**UNIVERSITY TECHNOLOGY SYDNEY (UTS)**

**UTS BROADWAY BUILDING**

**ACCESS REVIEW**

**Morris-Goding Accessibility Consulting**

UTS BROADWAY BUILDING
SYDNEY
LEVEL B3 BASEMENT FLOOR PLAN
7352_CBT185AK-00117.J

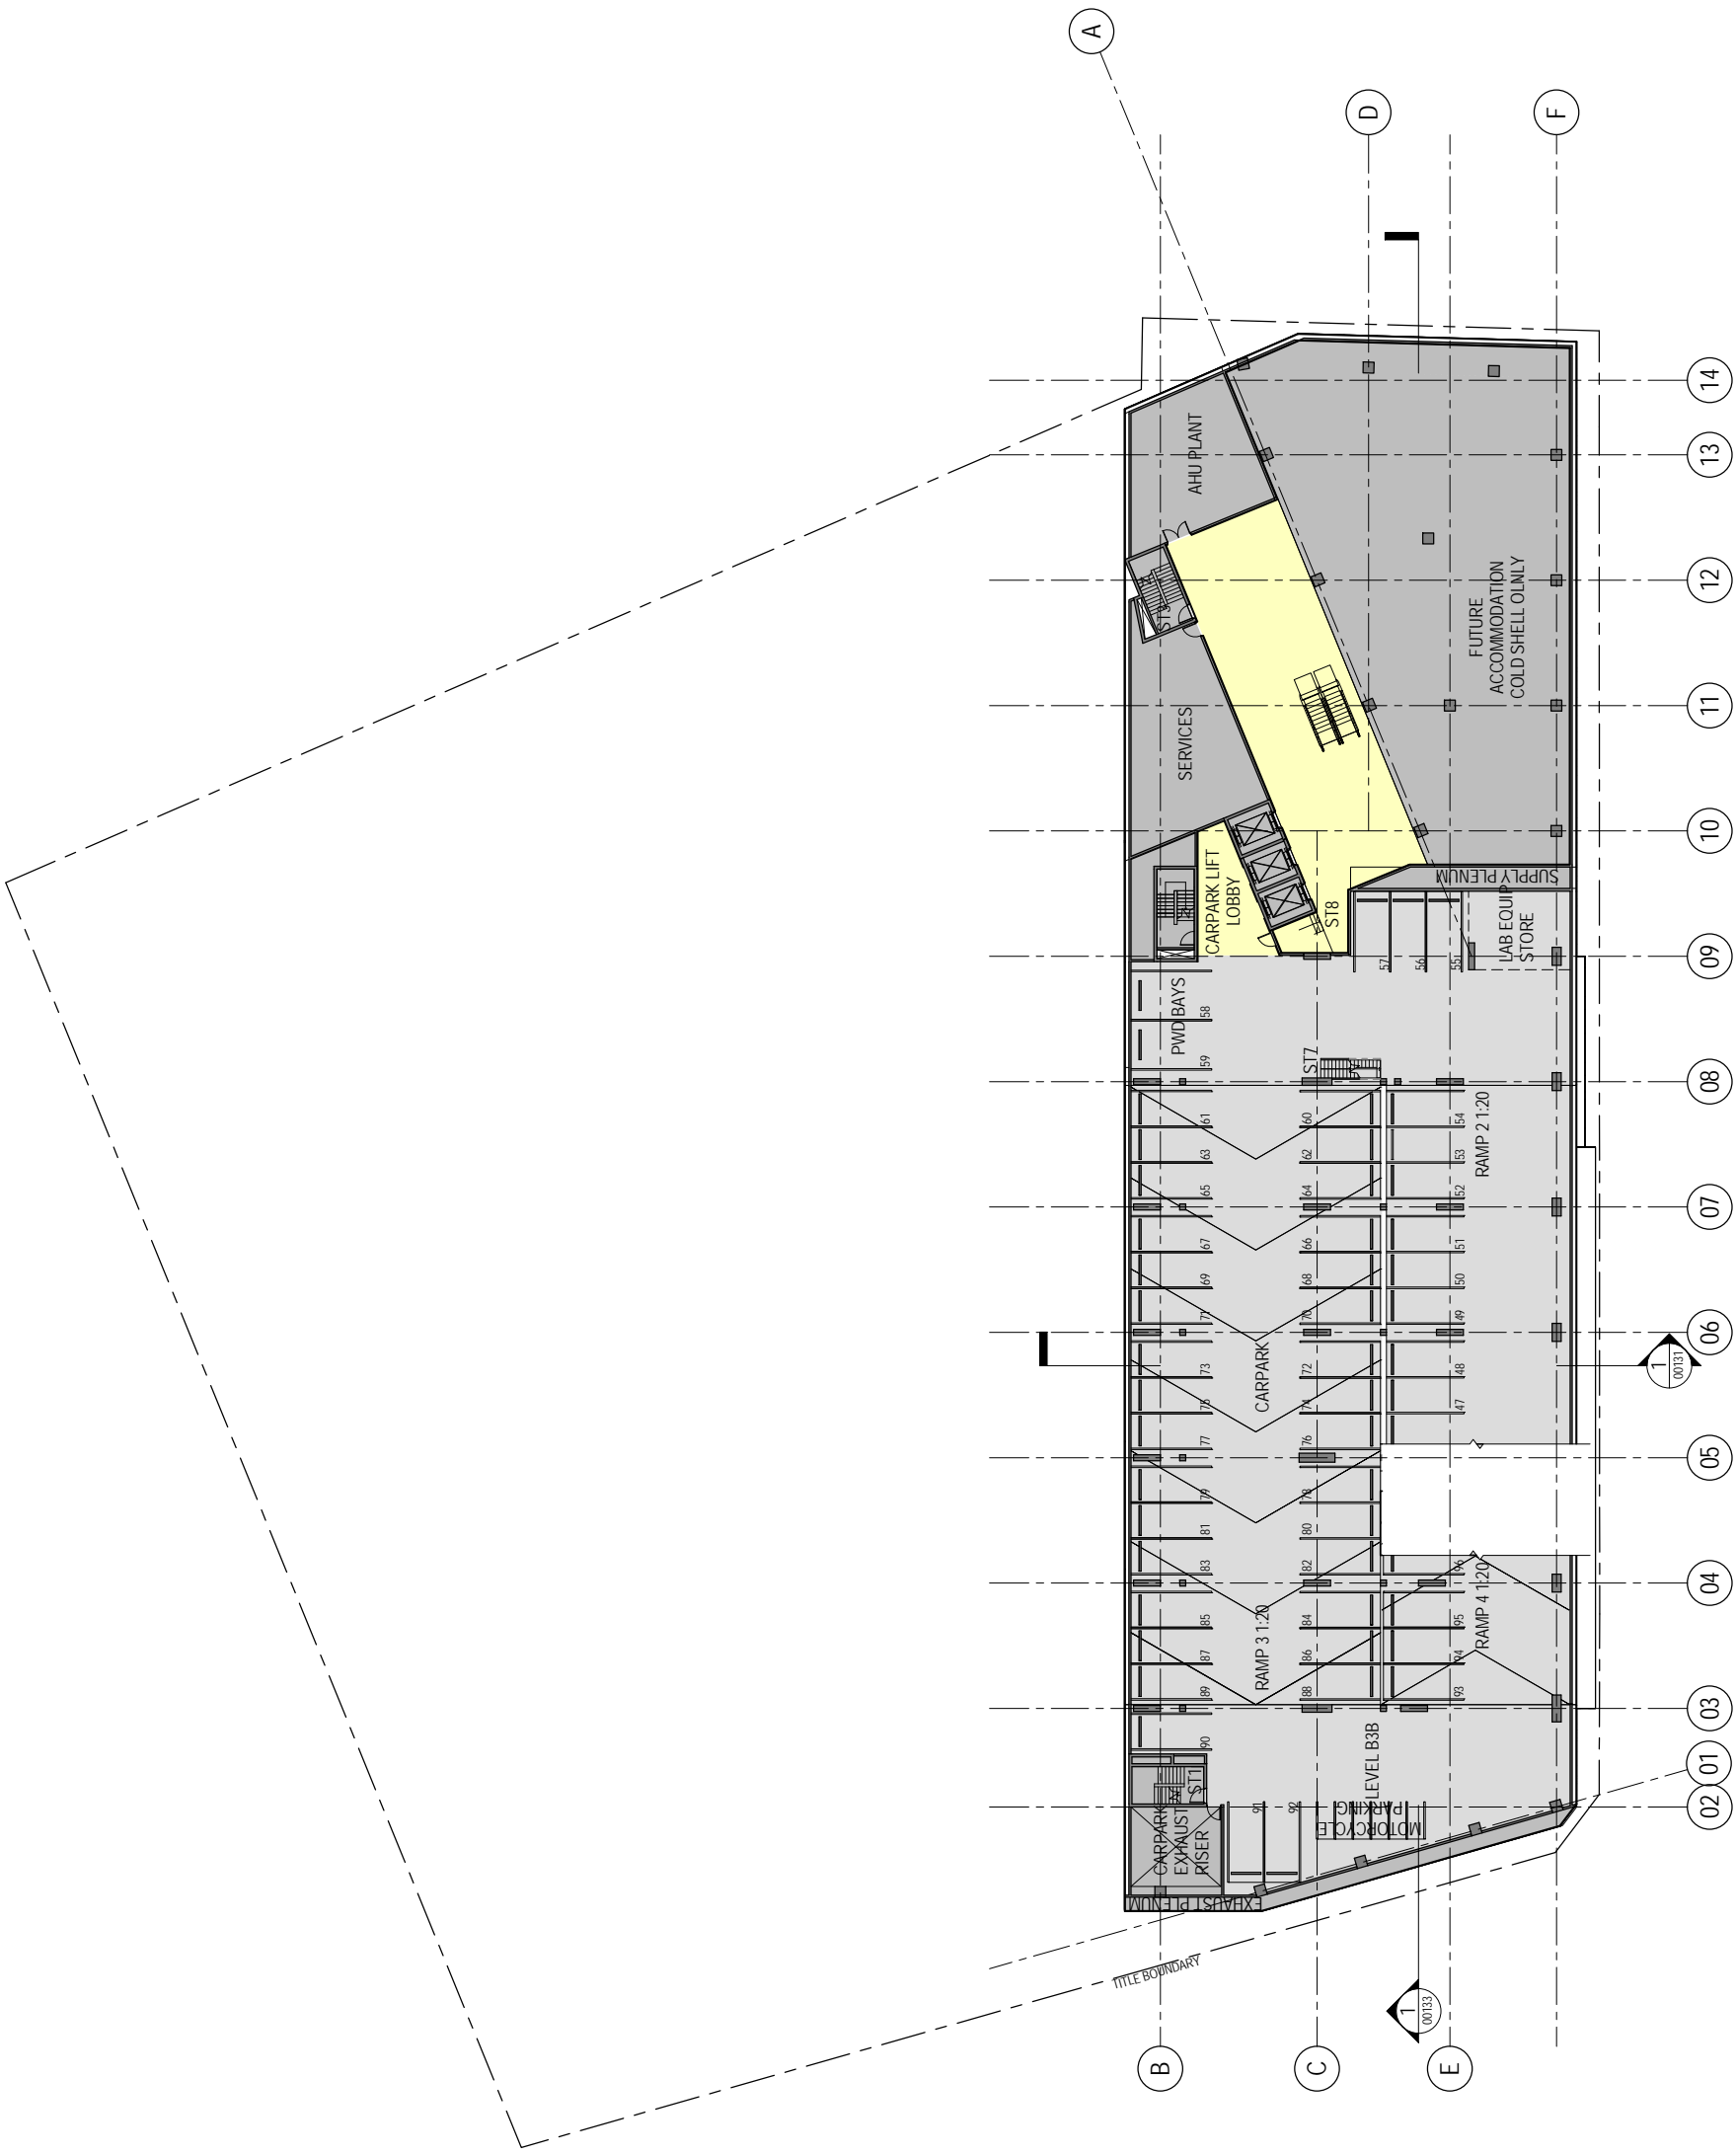
There is a basement car parking on Levels B2, B3 and B4 with a total of approximately 114 car spaces. There are no spaces designated as accessible for people with a disability on the drawings.

There are 2 spaces on each level located in the north-eastern corner of the car park with sufficient dimensions to create 2 accessible car spaces of 2.4metres in width with an adjacent 2.4metres shared zone in accordance with AS2890.6. These spaces are located on an accessible path of travel to lift which provides access to the upper levels of the building.

- (i) At least two accessible car spaces are to be provided in accordance with BCA and UTS Access policy.

UTS BROADWAY BUILDING
 SYDNEY
 LEVEL B1 BASEMENT FLOOR PLAN
 732 CB10/BAK-00115J
 18 FEBRUARY 2010

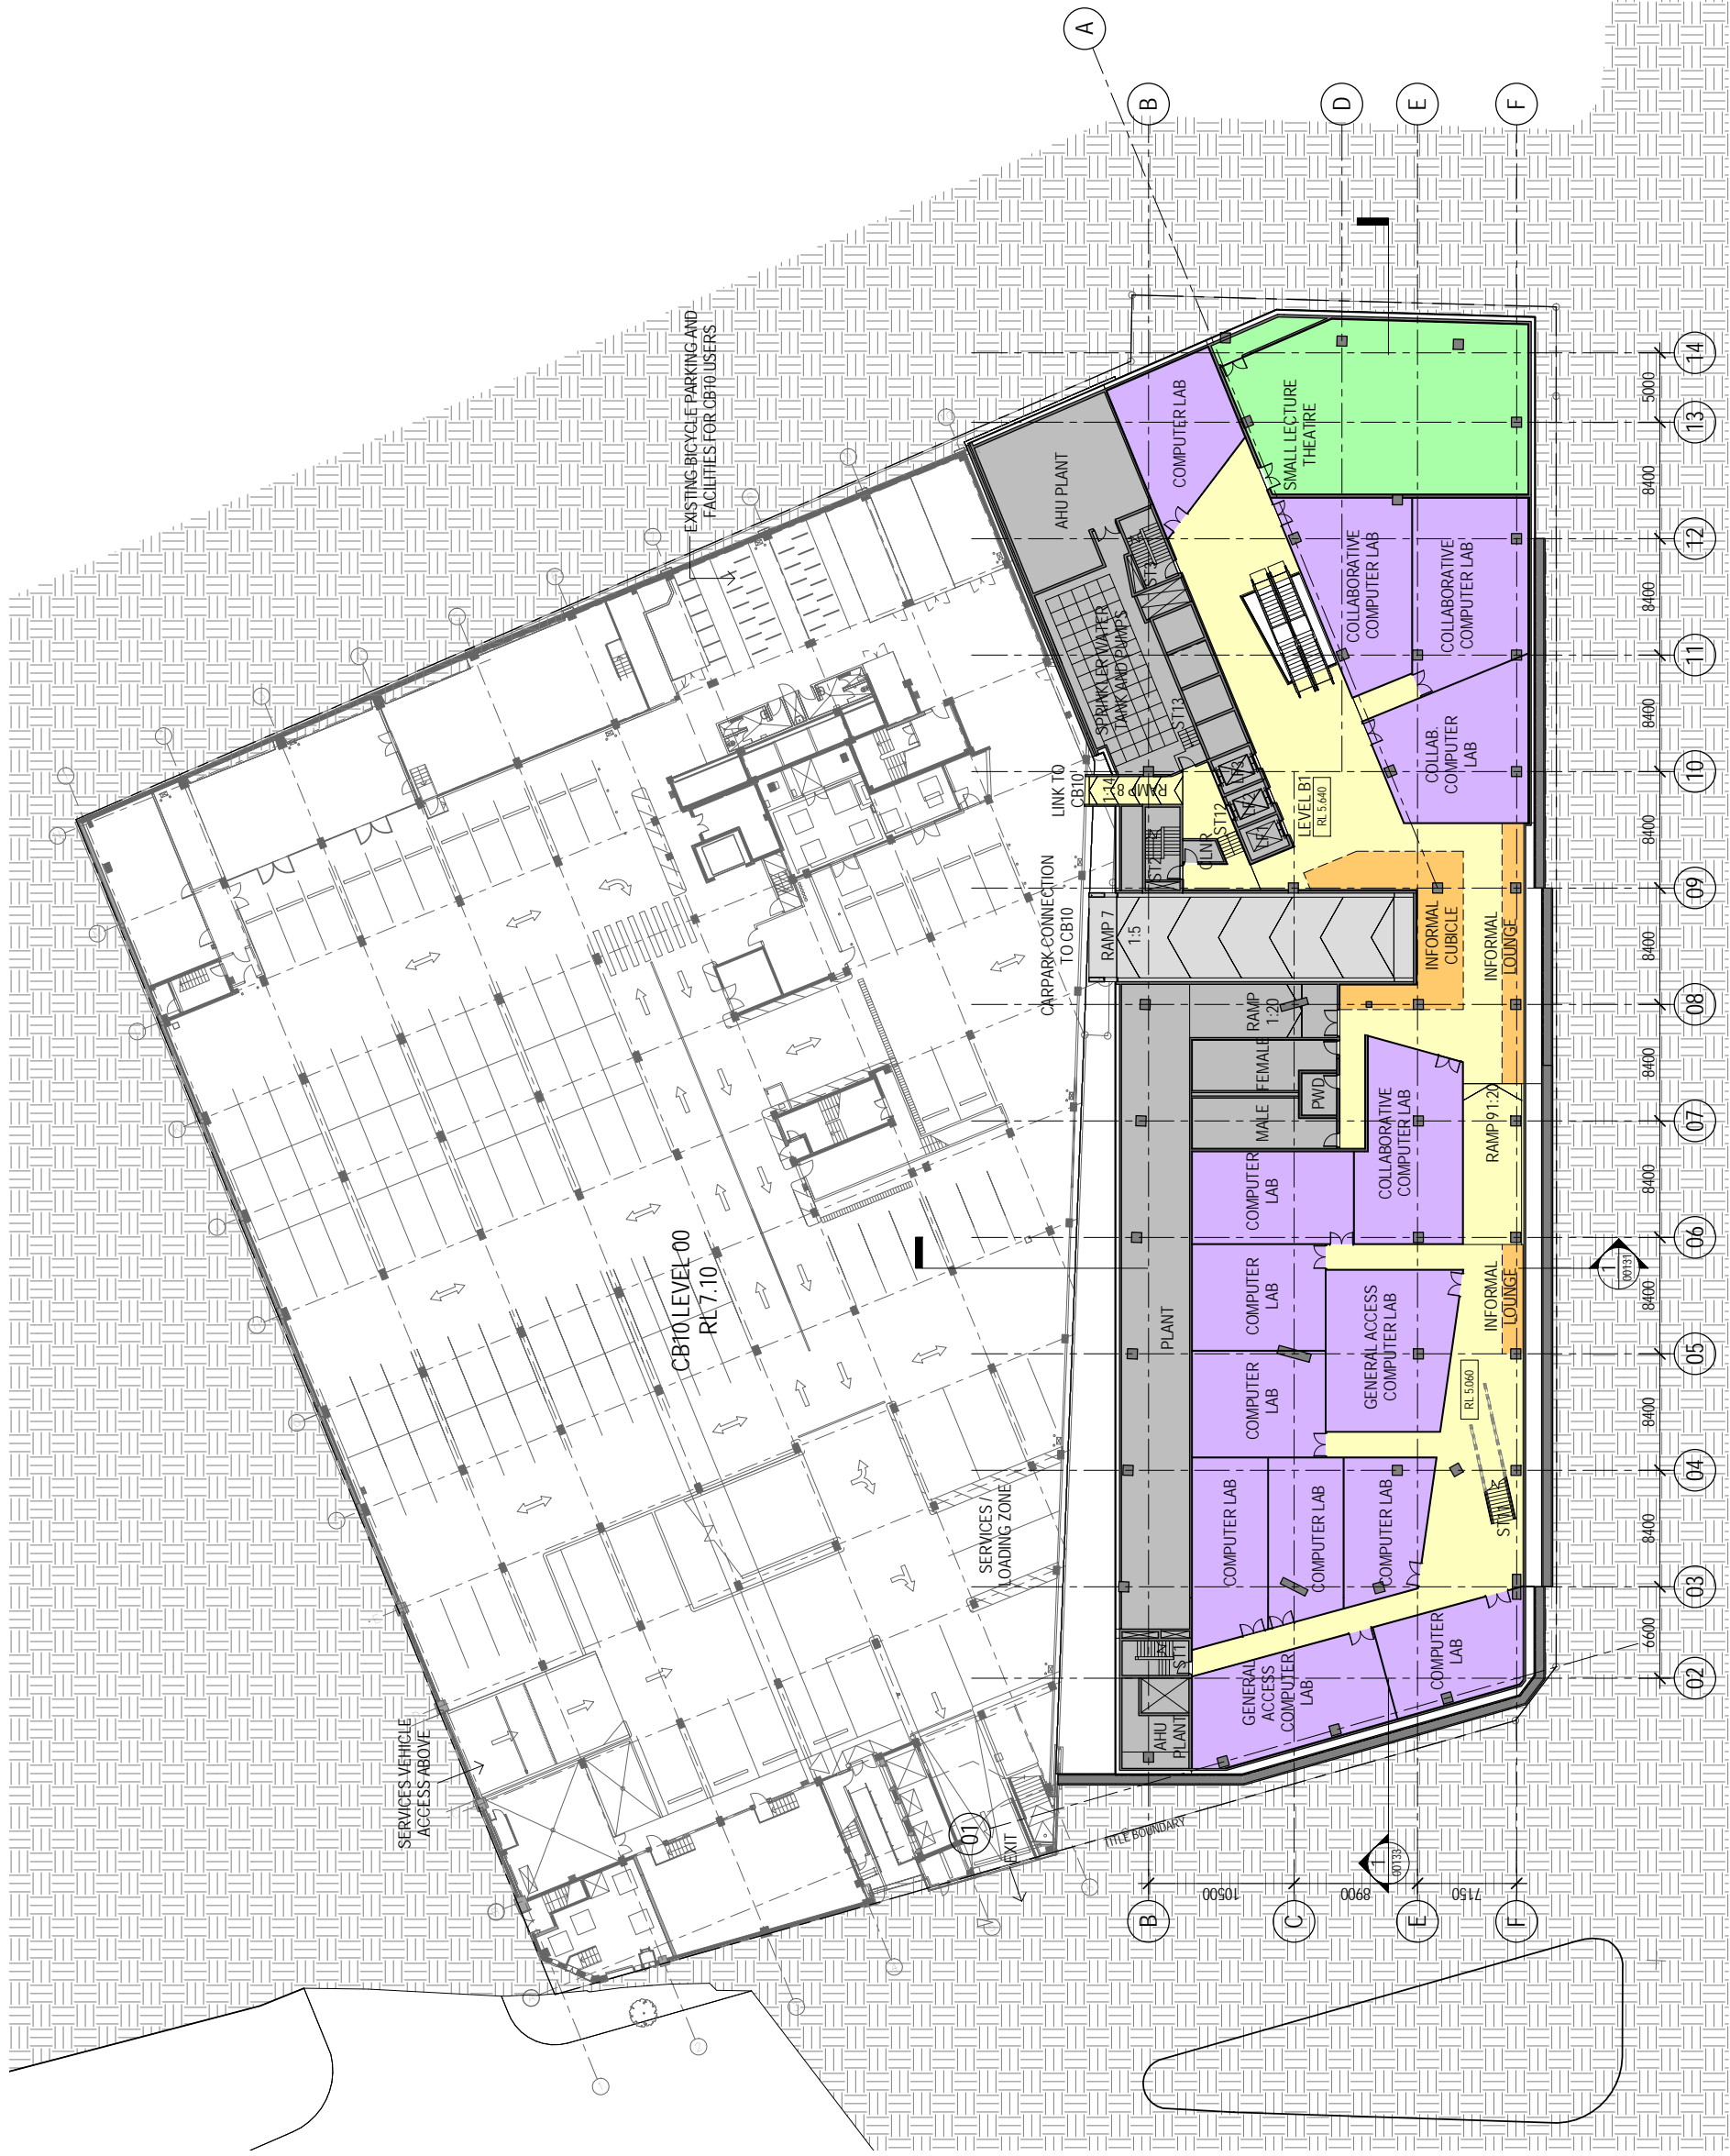
The only bank of toilet facilities indicated on these drawings is located on Level B1. There are no details provided on the layout of these facilities.

It is assumed that additional required toilet facilities are provided within the existing building and are able to be accessed via accessible walkway links between the two buildings.

- (i) At least one accessible toilet is to be provided where ever there is a bank of gender specific toilets with dimensions and layout compliant with AS1428.1:2009
- (ii) An ambulant user cubicle it to be provided in both gender specific toilets compliant with AS1428.1 :2009
